Subject: The Retreat at Timber Ridge PUD Development Plan, Review #2 (PUD-17-003)

The Planning Division of the Community Services Department has reviewed the Retreat at Timber Ridge PUD Development Plan, Review #2, has noted the minor updates to the regional trail easement and trail alignment on the development plan, and has no additional comments. Please refer to the original review comments below:

PUD  
DEVELOPMENT  
PLAN

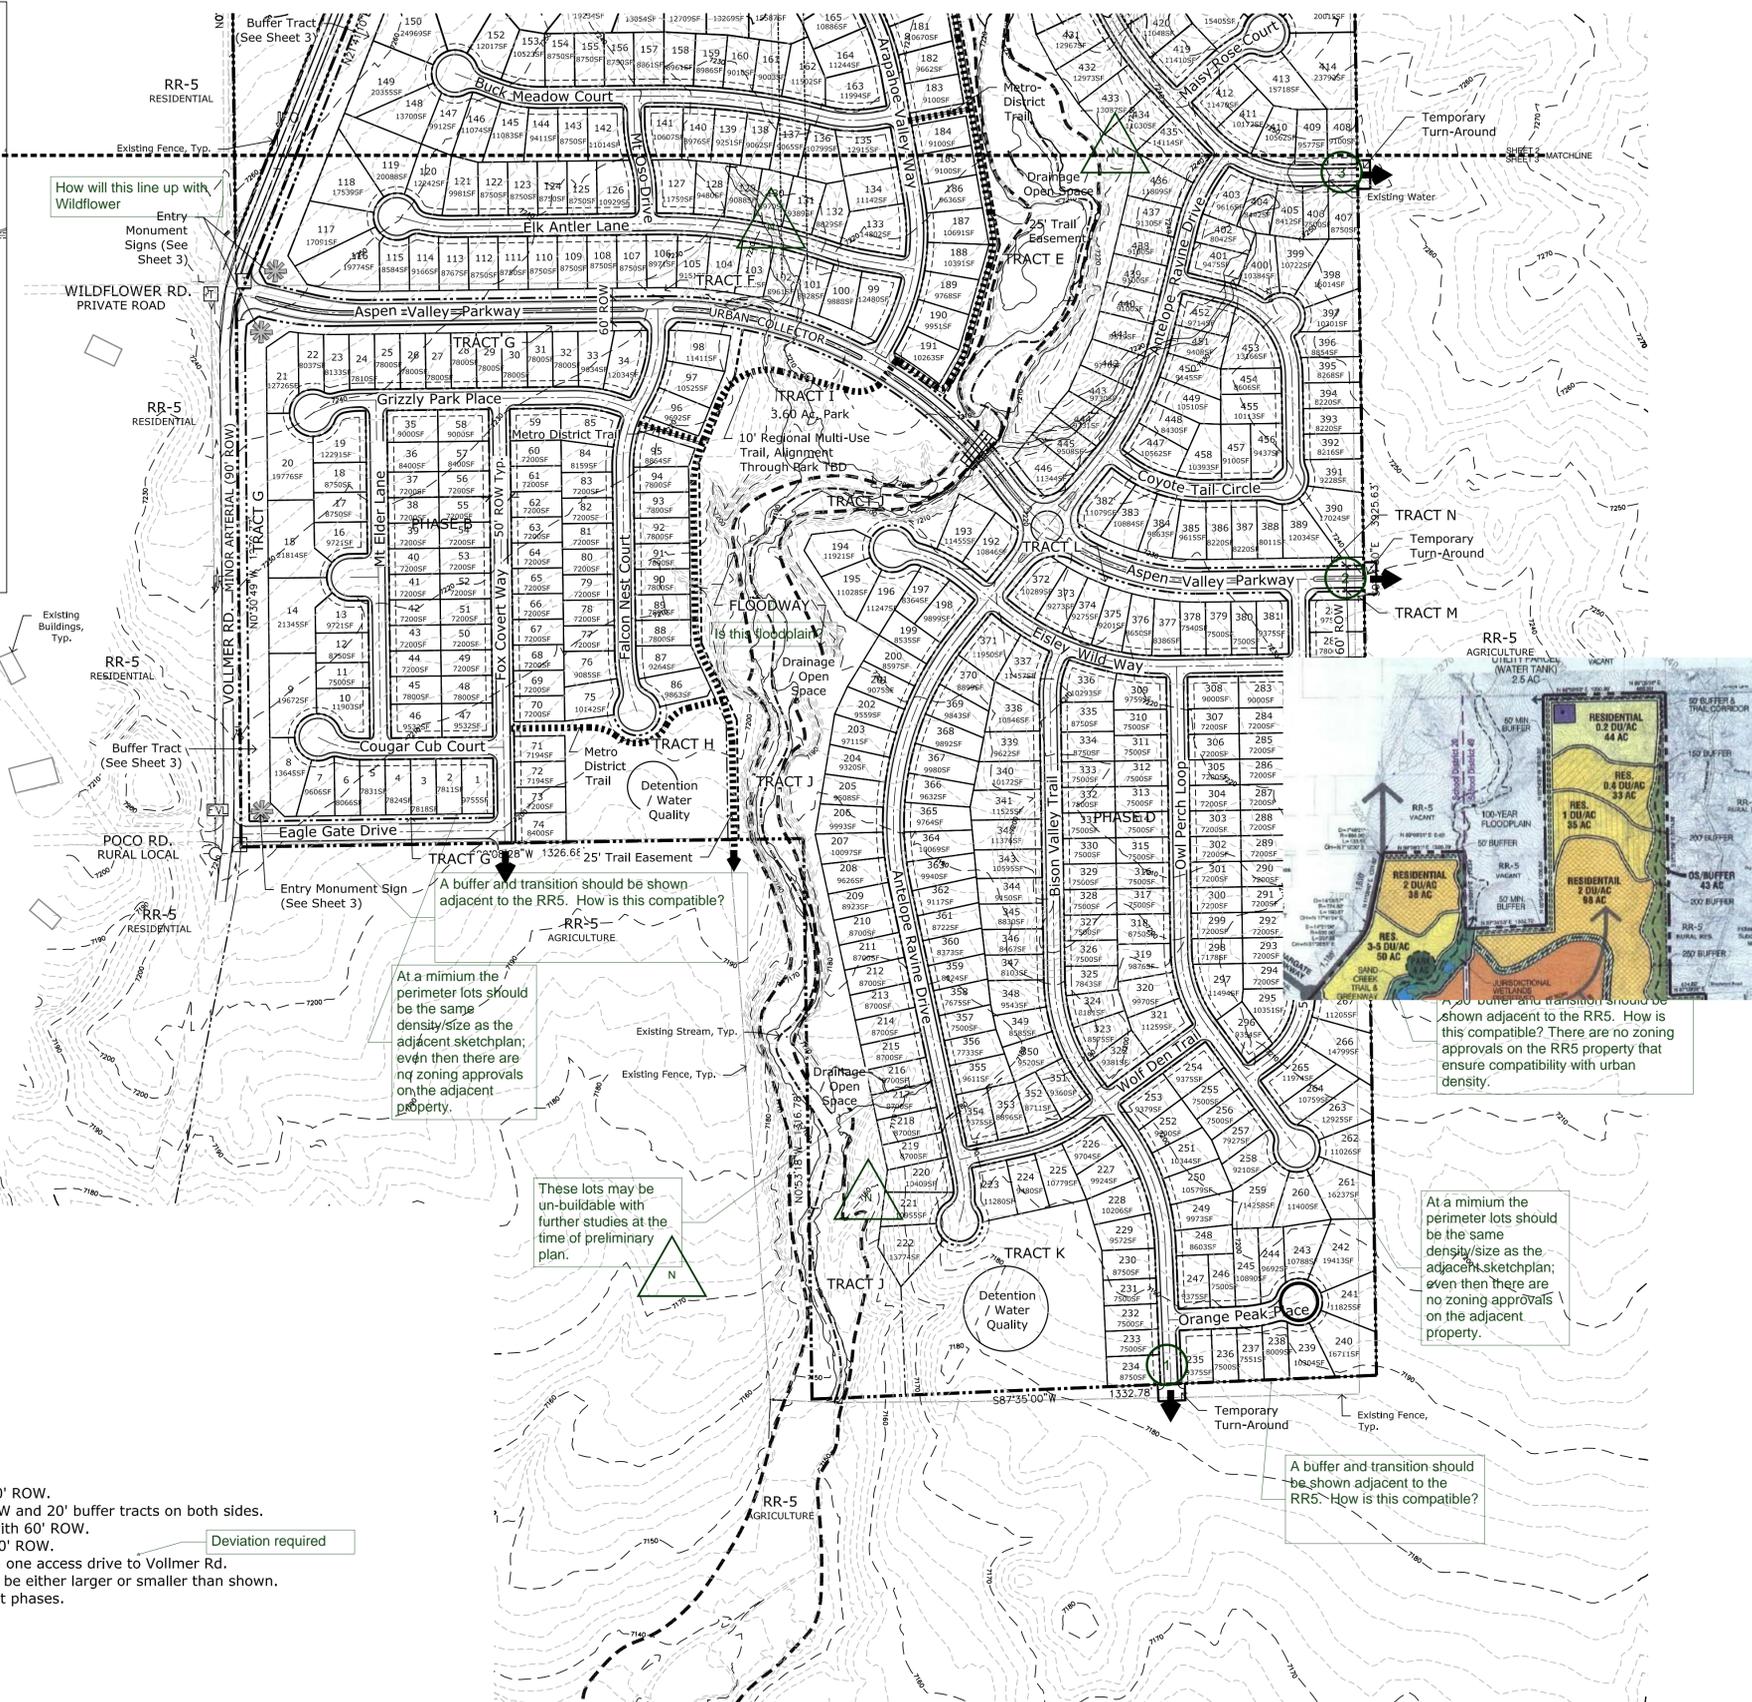
The PUD Development Plan shows 25-foot trail buffers along Sand Creek and Arroyo Lane. Parks staff recommends that all forthcoming preliminary plans and final plats show 25-foot trail easements within Tracts B, E, I, and J along the Sand Creek drainage, as well as the 25-foot trail easement along Arroyo Lane, and shall dedicate these 25-foot wide regional trail easements to the County for the County’s construction and maintenance of public multi-use trails on forthcoming final plats.

Recommend to the Planning Commission and Board of County Commissioners that approval of the Retreat at TimberRidge PUD Rezone/Development Plan include the following conditions, to be implemented on all forthcoming preliminary plans and final plats: (1) provide to El Paso County 25-foot public trail easements along the Sand Creek Drainage and Arroyo Lane that allow for public access, as well as construction and maintenance by El Paso County of primary regional trails, and these easements shall be shown on forthcoming preliminary plans and final plats, and the aforementioned easements shall be dedicated to El Paso County on forthcoming final plats; and (2) require fees in lieu of land dedication for regional park purposes. The amount of \$196,174 was calculated for informational purposes and is based upon the preliminary lot layout and will be adjusted as preliminary plans and final plats are submitted.”
